Please ask for: Mrs D Johnson
Email: daun.johnson@arun.gov.uk
Telephone: 01903 737762
Our Ref: BR/17/22/PL
Your Ref:
Date: 31st January 2022

Application for Planning Permission

Development: Change of Use from hairdressers (Class E(a)) to Hot Food Takeaway (Sui Generis) with low level ducting system at the rear of the ground floor commercial unit. This site is in CIL Zone 4 (Zero Rated) as other development.
Location: 91 Hawthorn Road Bognor Regis PO21 2BE

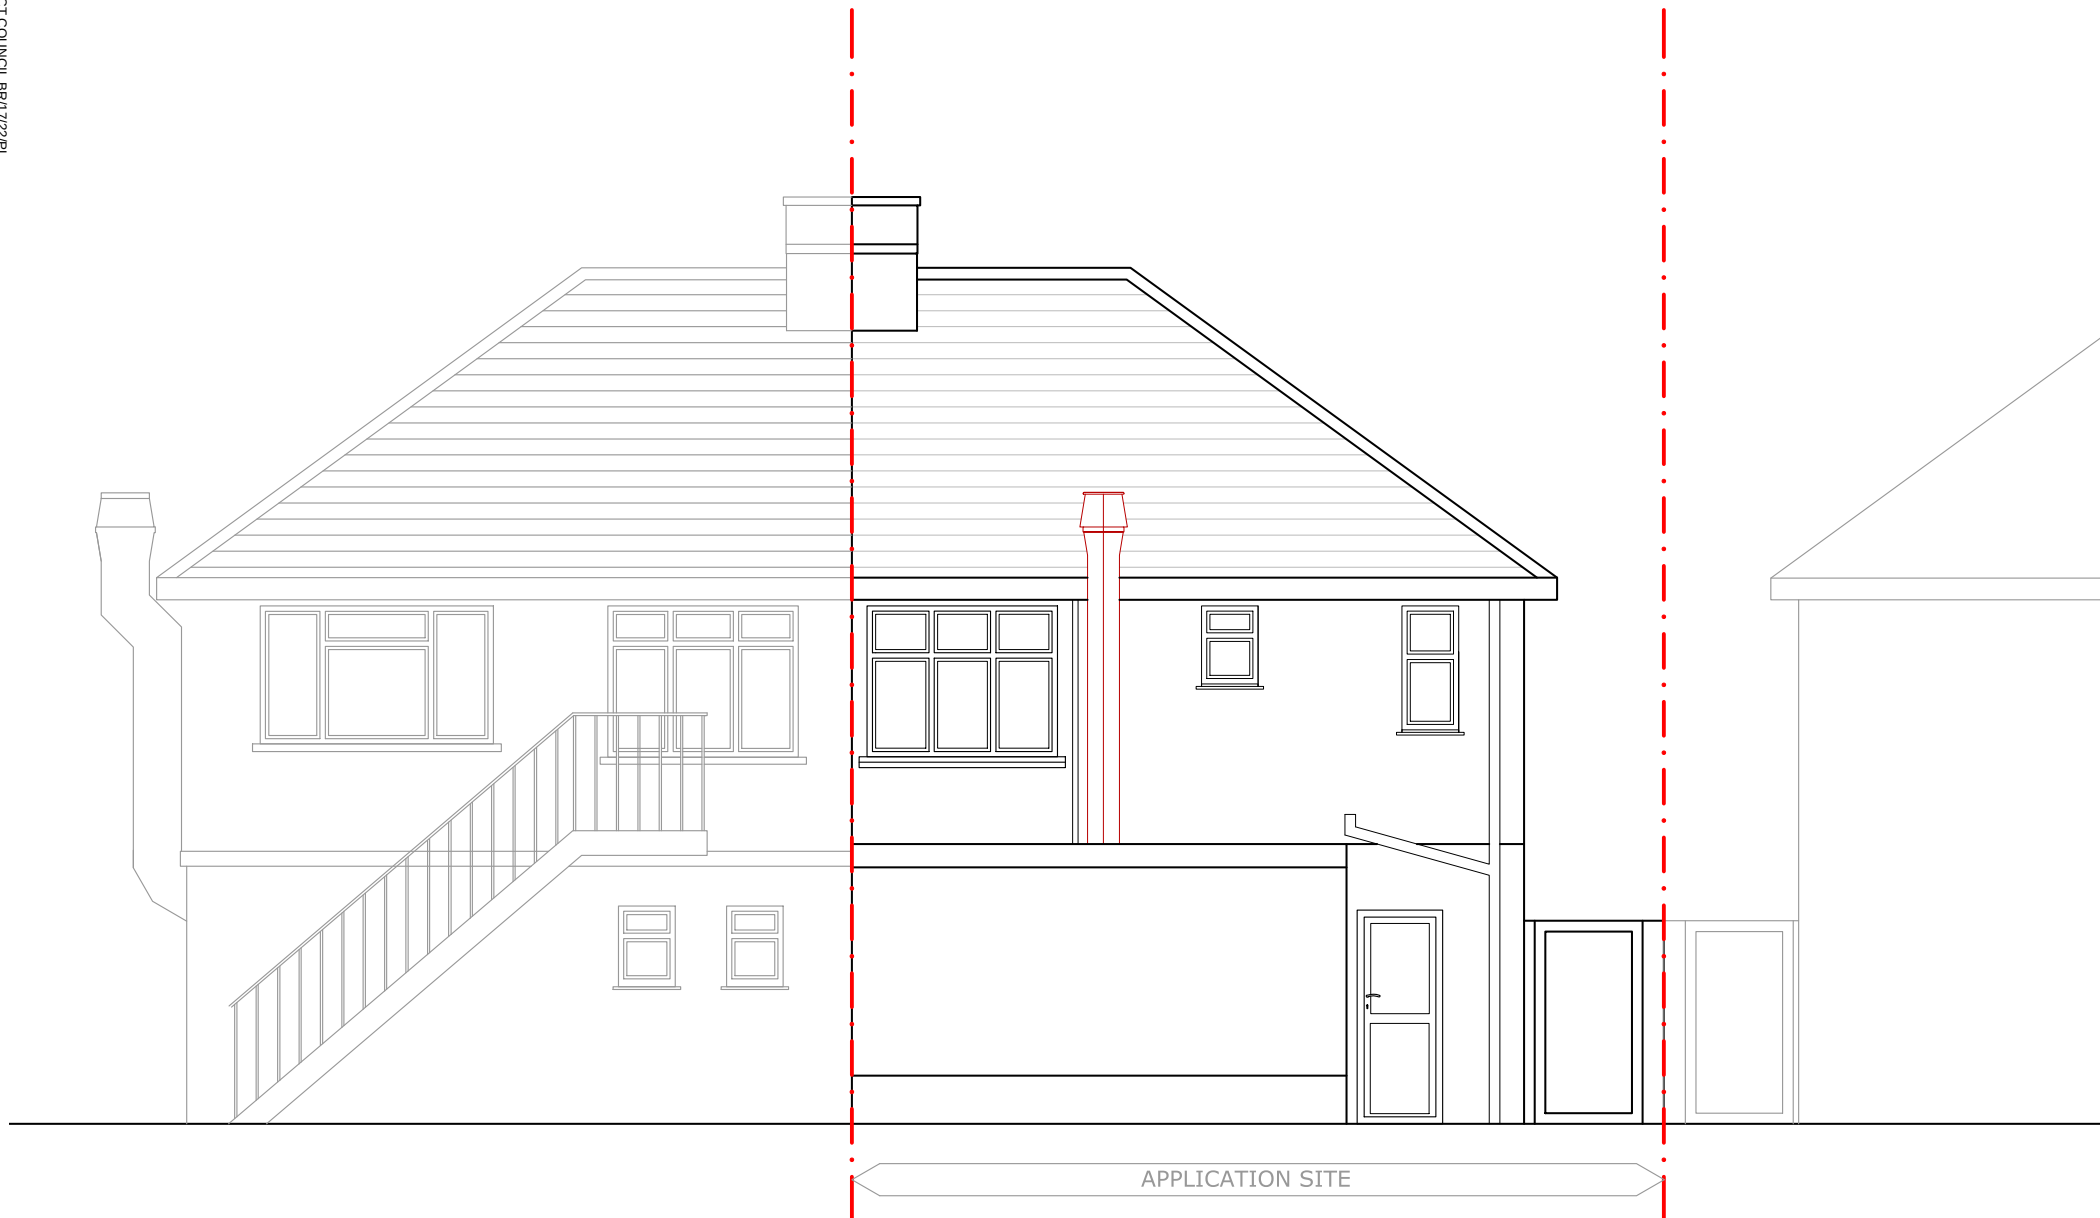
The proposed side elevation and floor plan do not accord. Please amend accordingly.
